CITY OF ALBUQUERQUE

September 28, 2022

Re: Rio Grande Apartments
2211 Rio Grande Blvd. NW
Traffic Circulation Layout
Architect's Stamp 09-13-22 (H12-D024)

Based upon the information provided in your submittal received 09-19-22, the above referenced plan cannot be approved for Building Permit until the following comments are addressed:

SITE PLAN
SCALE: 1" = 20'-0"

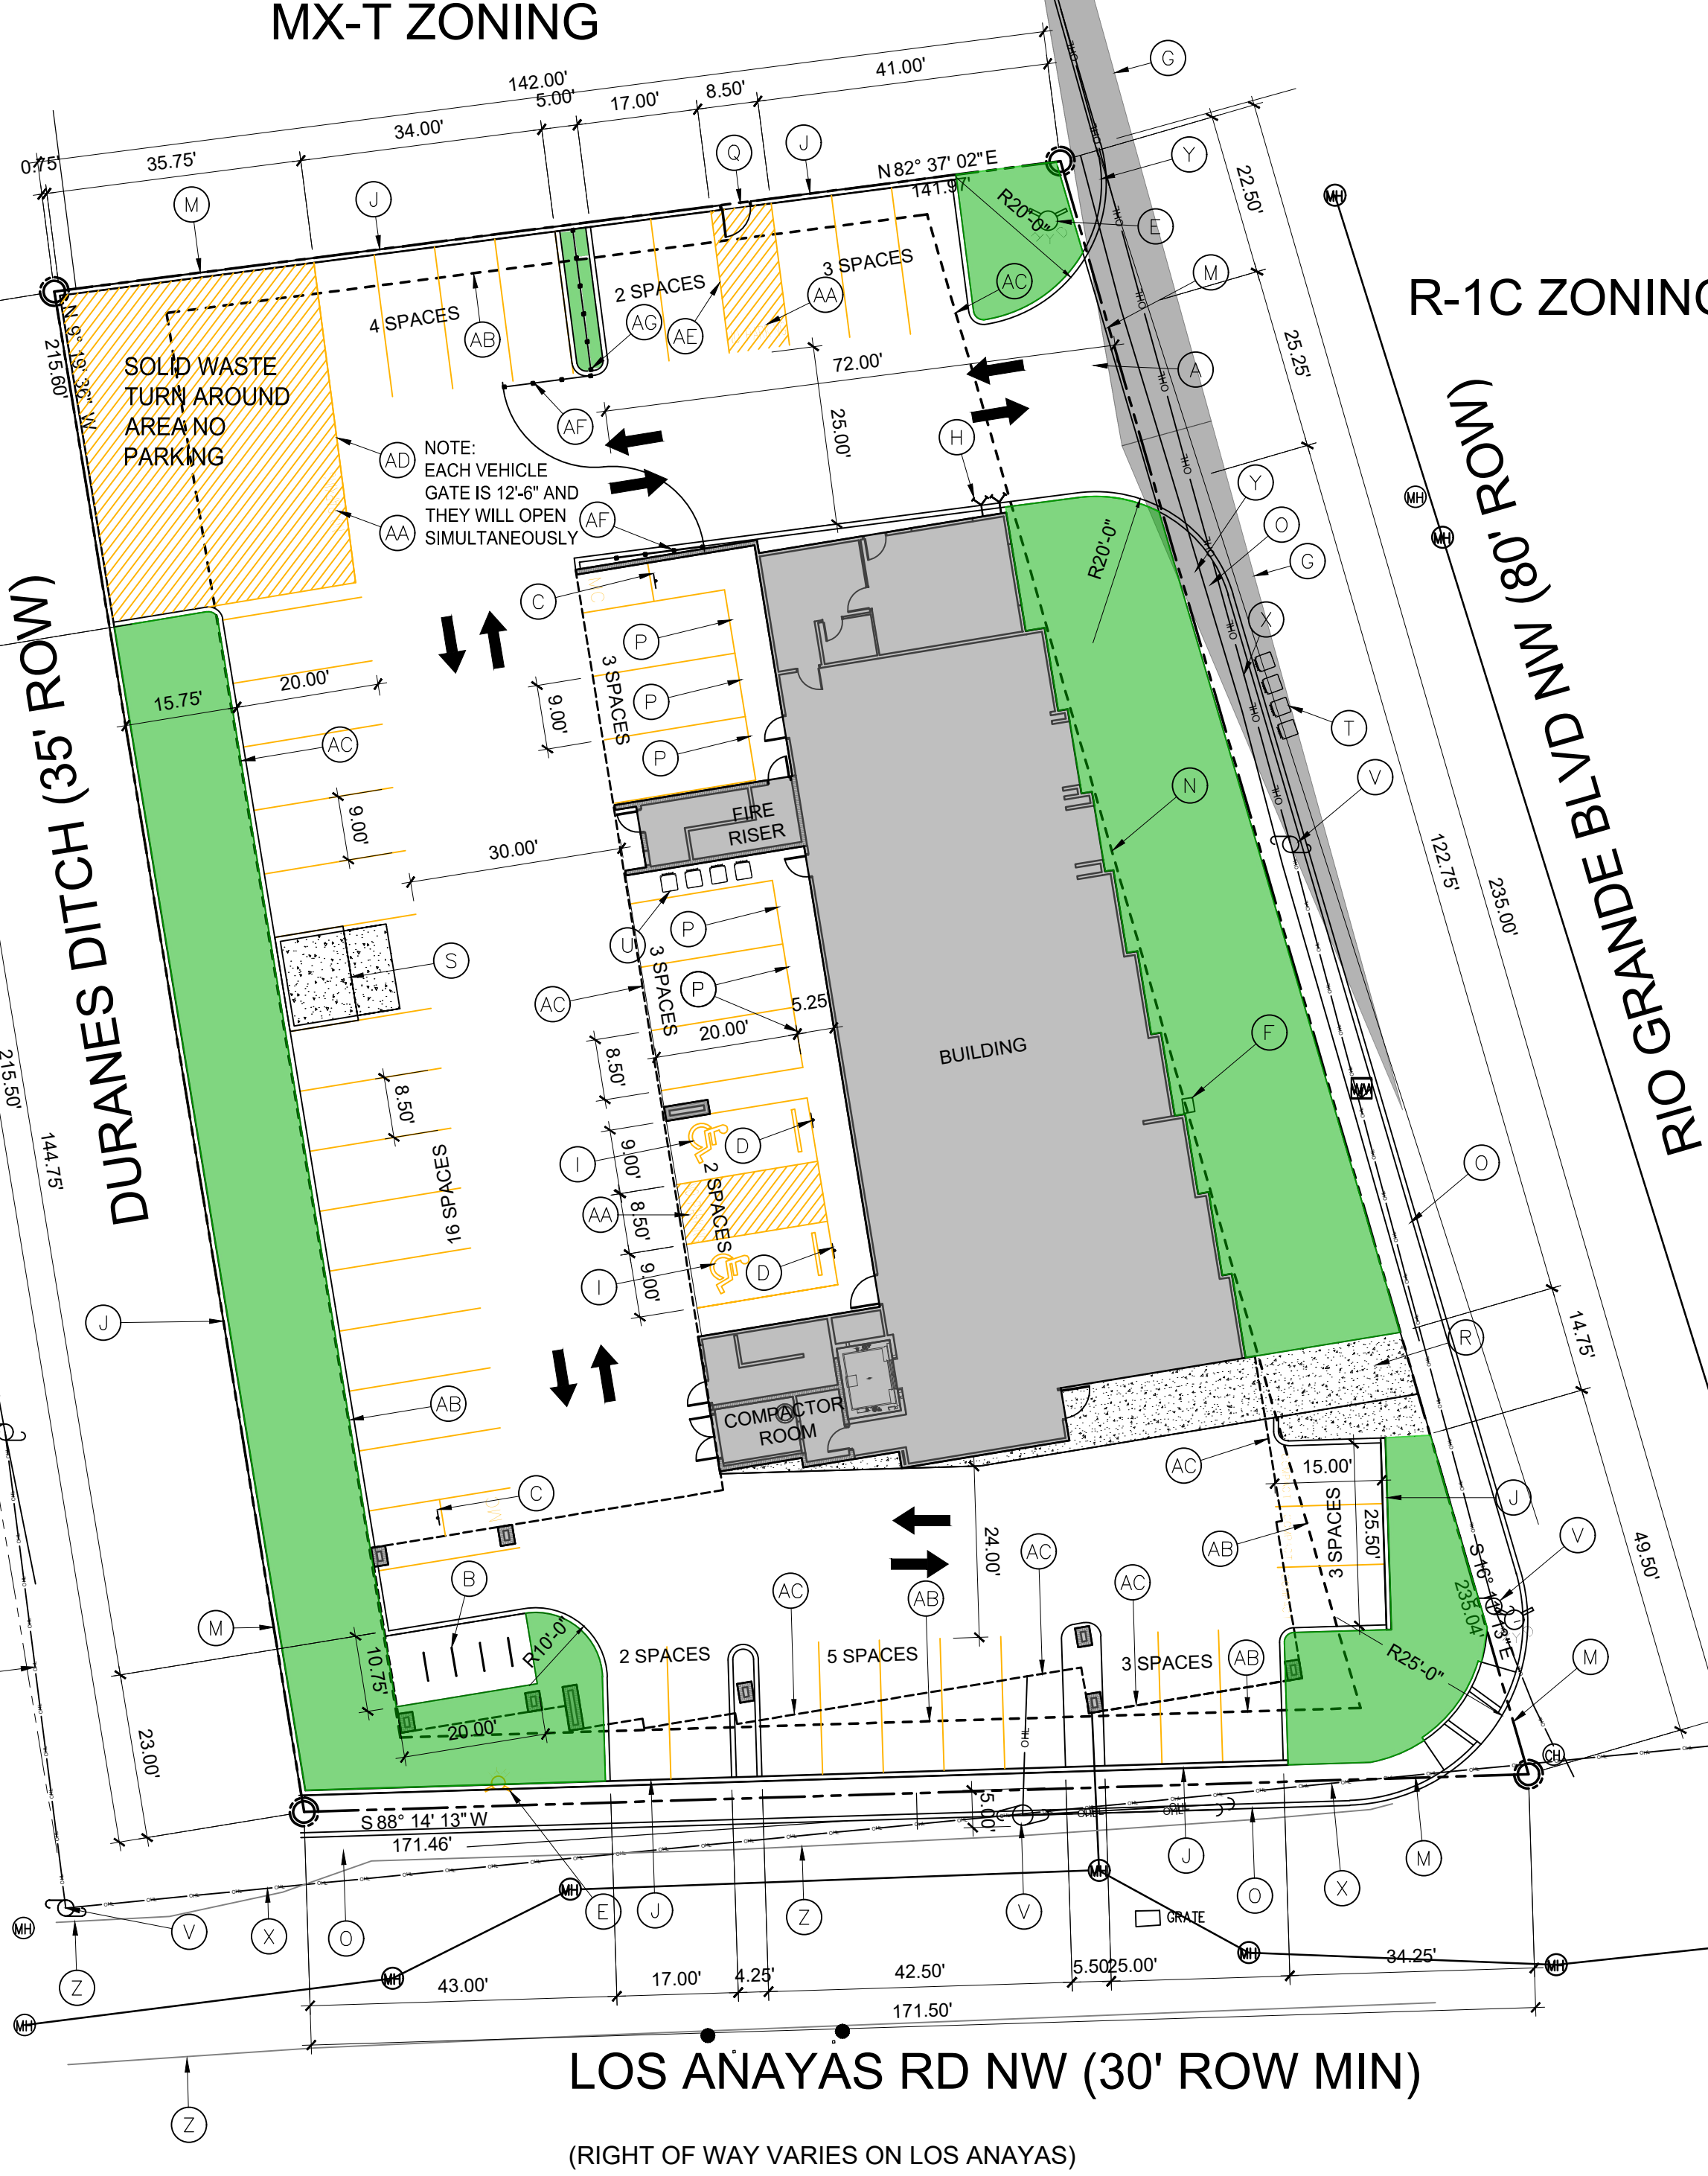
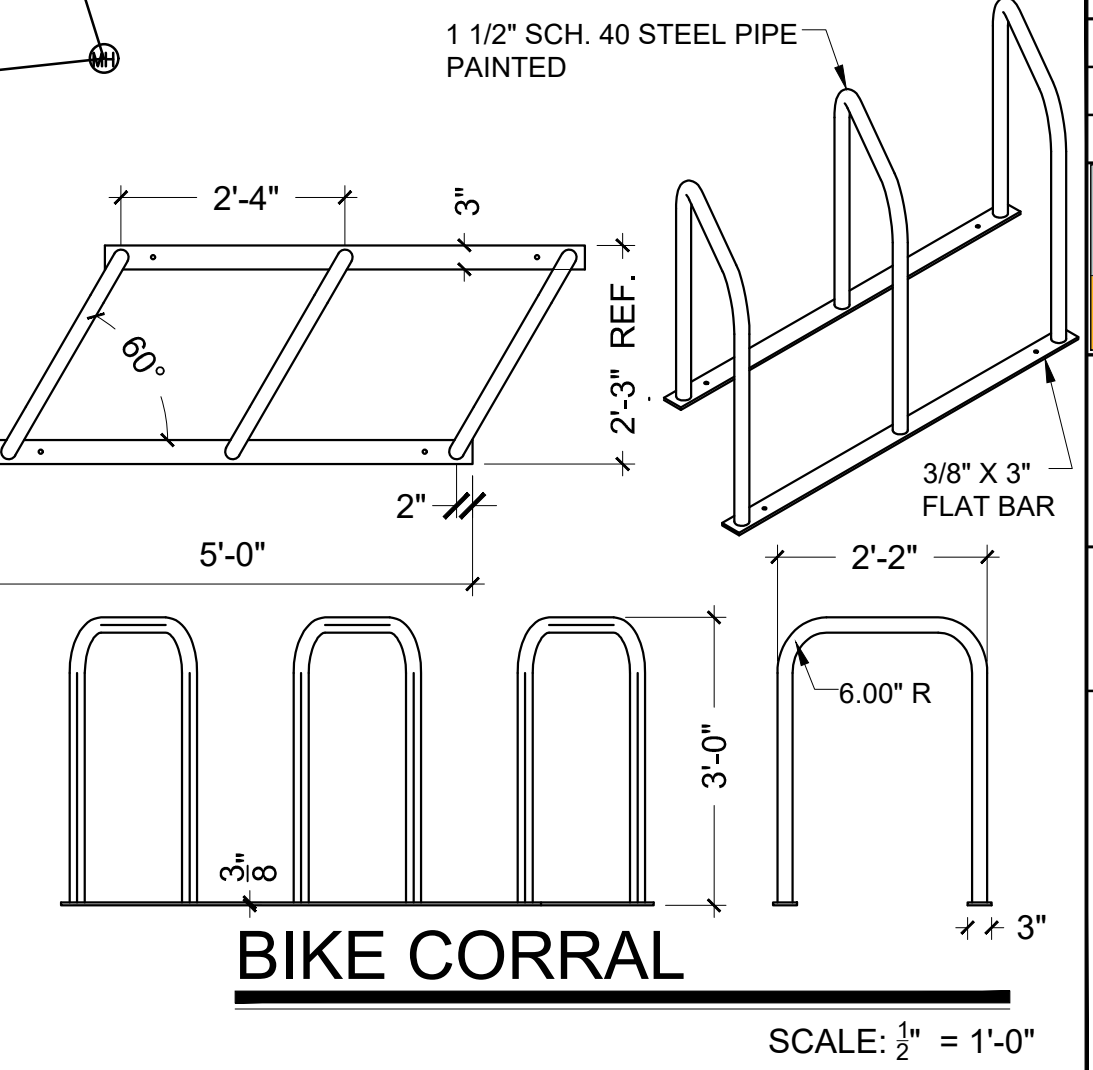
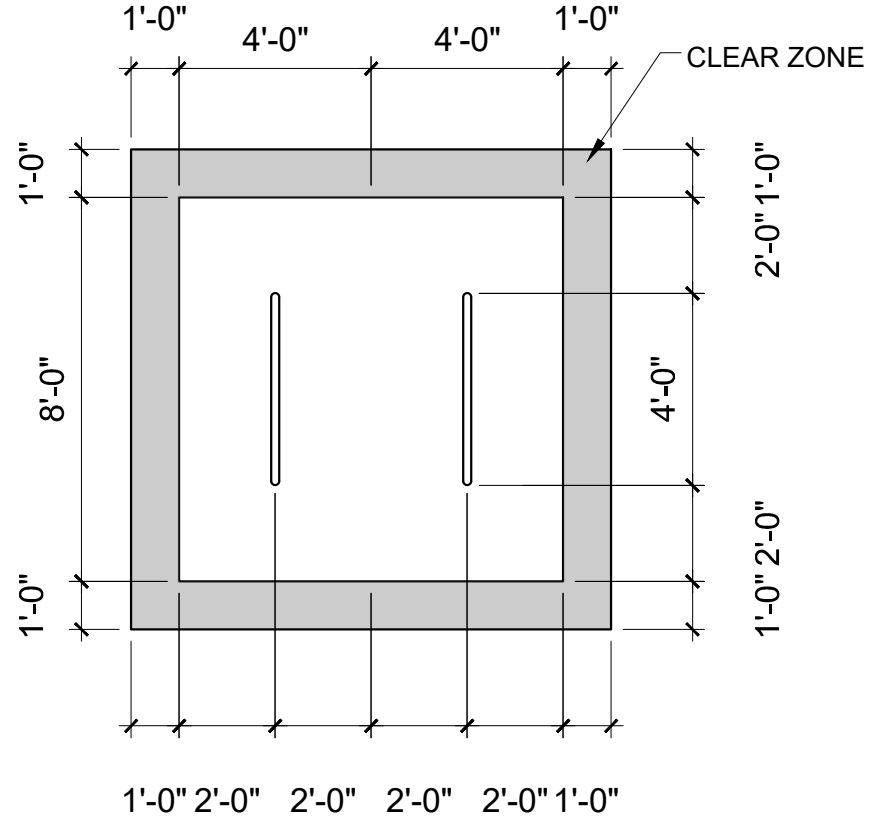
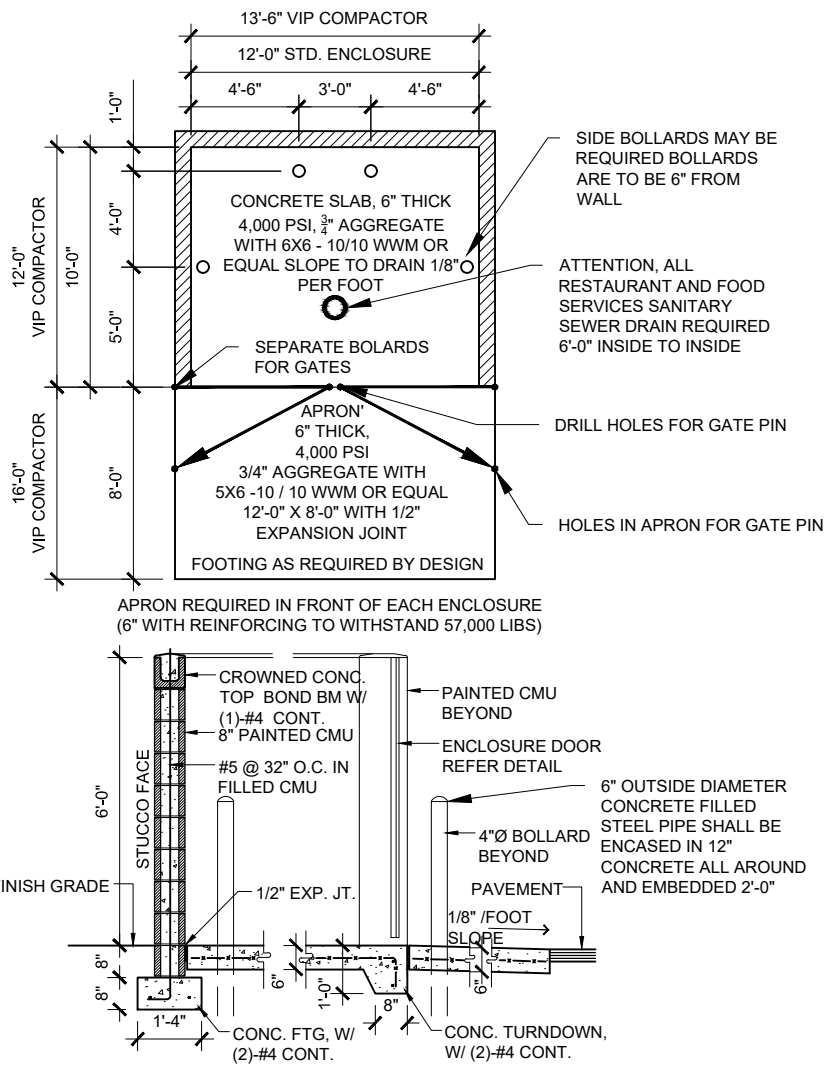
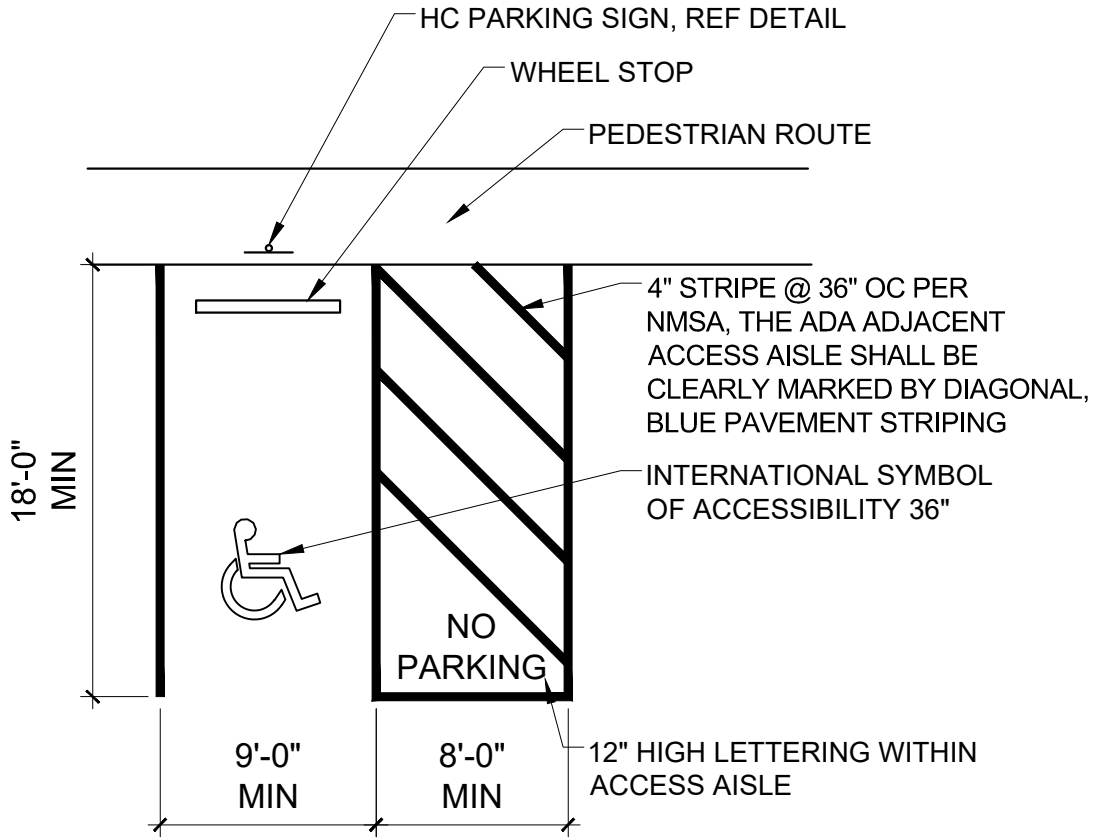
1. Per City requirement, please provide 50 ft. access throat length. See attached table 7.4.81
2. Due to proposing a gate (keynote AF), Please show Turning movement Template on the site plan.

3. Label the compact parking spaces by placing the words "**COMPACT**" on the pavement of each space. For the parking spaces at the southeast of the site.

4. Sheet A-501 is missing.
5. The ADA accessible parking sign must have the required language per 66-7-352.4C NMSA 1978 "**Violators Are Subject to a Fine and/or Towing.**" Please call out detail and location of signs.

6. ADA curb ramp at the corner of Rio Grande and Los Anayas Rd must be updated to current standards and have truncated domes installed.
7. Motorcycle parking spaces shall be designated by its own conspicuously posted upright sign, either free-standing or wall mounted per the zoning code.

8. The pavement marking "MC" should be shown in the opposite direction for Motorcycles entering the parking space.
9. A 5 ft. keyway is required for dead-end parking aisles at the south side of the site.

10. Per DPM, a 6 ft. wide ADA accessible pedestrian pathway is required from the ADA parking stall access aisles to the building entrances. Please clearly show this pathway and provide details.

11. ADA accessible pedestrian pathway should not be placed behind parking space or adjacent to a vehicular way. Vehicle and pedestrian/wheel chair conflicts should be avoided as much as possible.

12. All sidewalks along streets should be placed at the property line.

13. Parking areas shall have barriers to prevent vehicles from extending over public sidewalk, public right-of-way, or abutting lots.
14. Refuse vehicle maneuvering shall be contained on-site. The refuse vehicle shall not back into the public right of way.; provide a copy of refuse approval.

15. Provide a copy of Fire Marshal approval.
16. It is not apparent what type of pavement surface is being proposed. A hard driving surface will be required as part of this proposed project for parking area and drive aisles.

17. Please specify the City Standard Drawing Number when applicable.
18. Unused curb cuts must be replaced with sidewalk and curb & gutter. A build note must be provided referring to the appropriate City Standard drawing.
